# Outer Dowsing Offshore Wind

## 5.1 Consultation Report

### Annex 5.1.4B Section 42 Consultation Responses

Document Reference: 5.1.4B

Figure 13.1 Marine Archaeology Study Area

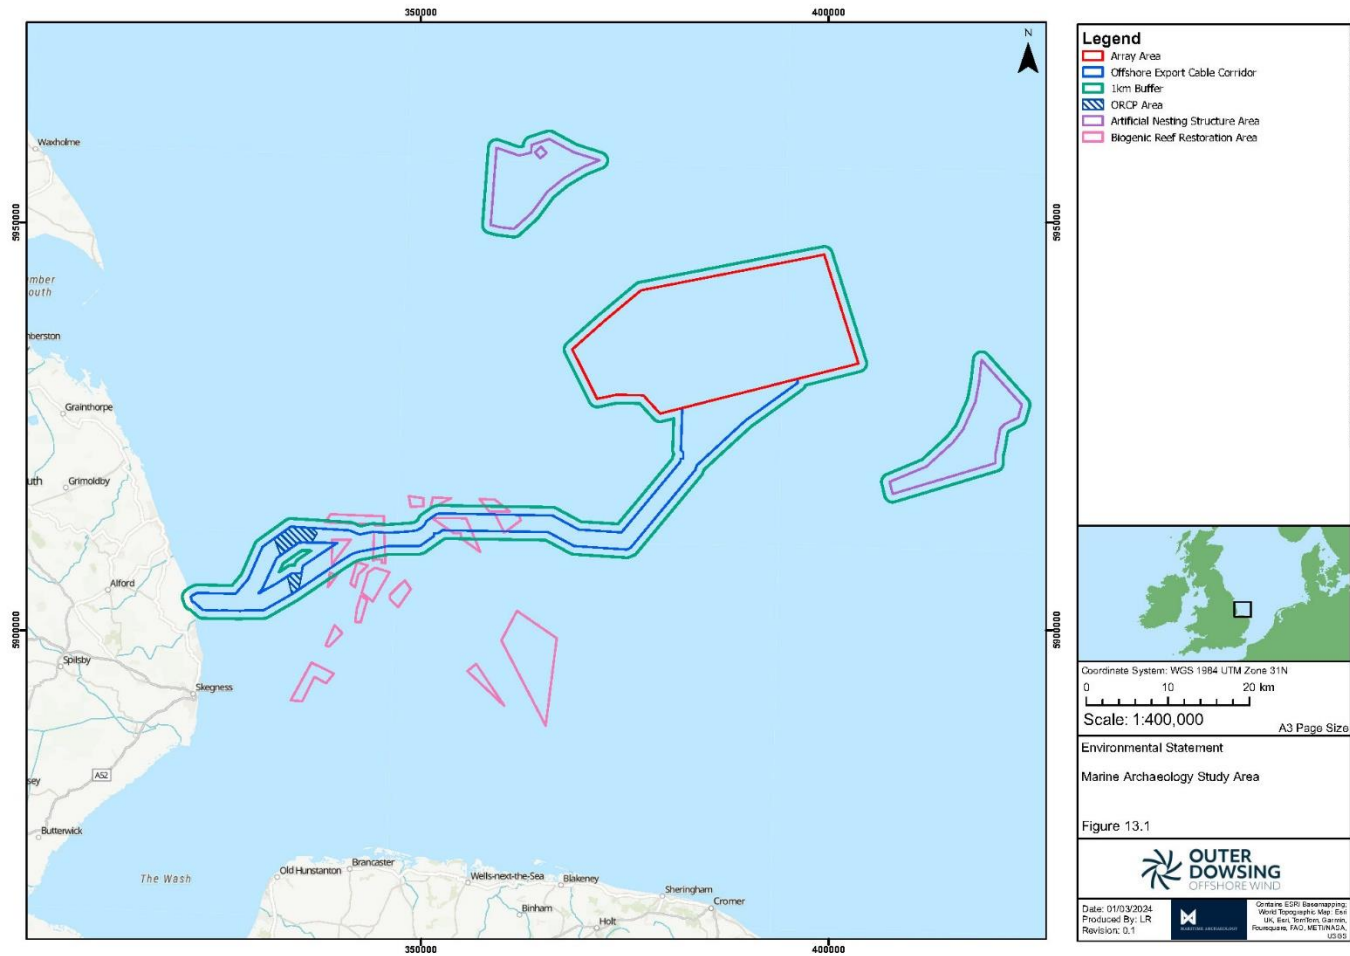
33	Historic England	P2_11	Paragraph 13.4.6 (Compensation areas) - we note that the three proposed compensation areas (as illustrated in Figure 13.1) will be assessed within any subsequent ES. We therefore cannot offer any further comment as this stage on suitability of any proposed historic environment mitigation measures.	The Applicant has noted this response. Mitigation measures are outlined in Chapter 13 Marine and Intertidal Archaeology (document reference 6.1.13) where required and an Outline Written Scheme of Investigation (WSI) submitted with protocols and practices to be incorporated in the final WSI and during construction.
34	Historic England	P2_11	The use of terms in this paragraph lacks clarity. The EIA Scoping Opinion published by the Planning Inspectorate (9th September 2022) sets the scope of the (environmental) assessment to be conducted. The PEIR should therefore identify marine archaeological and cultural heritage receptors that could be impacted (positively or negatively) by the proposed project. We also request that the term "marine archaeological and cultural heritage receptors" is replaced with Historic Environment (as defined in National Policy Statements, published and draft). We must also request that you	The Applicant has updated the terminology used to refer to Historic Environment and the paragraph has been amended accordingly.

Figure 13.9 Records and Geoaerchaeological Features within the Array Area

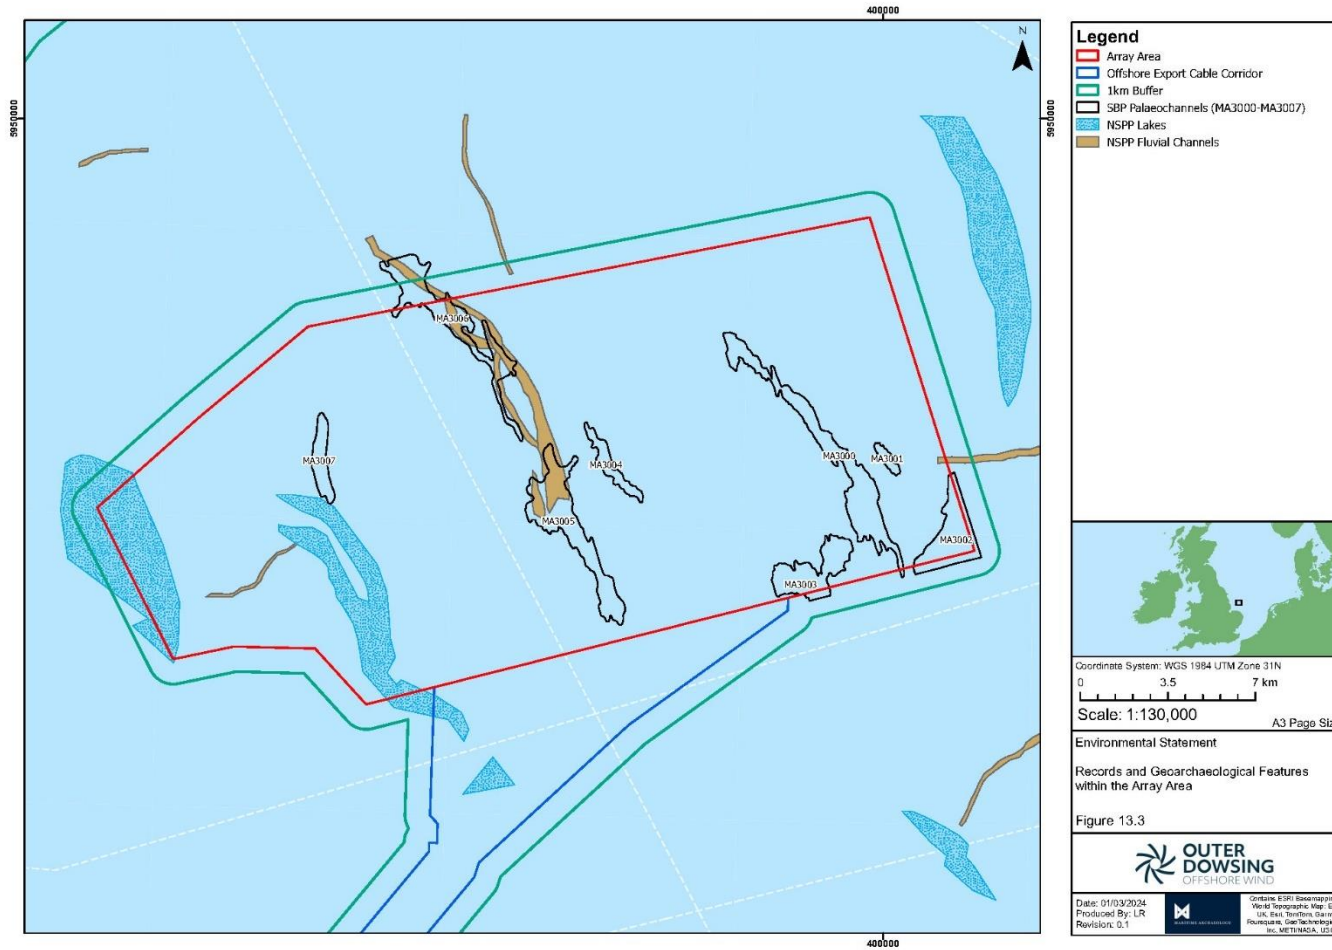
49	Historic England	P2_11	the use of references e.g. “MA3005” are not explained in the Key to this figure or in any accompanying text in this chapter.	This has been amended by the Applicant.
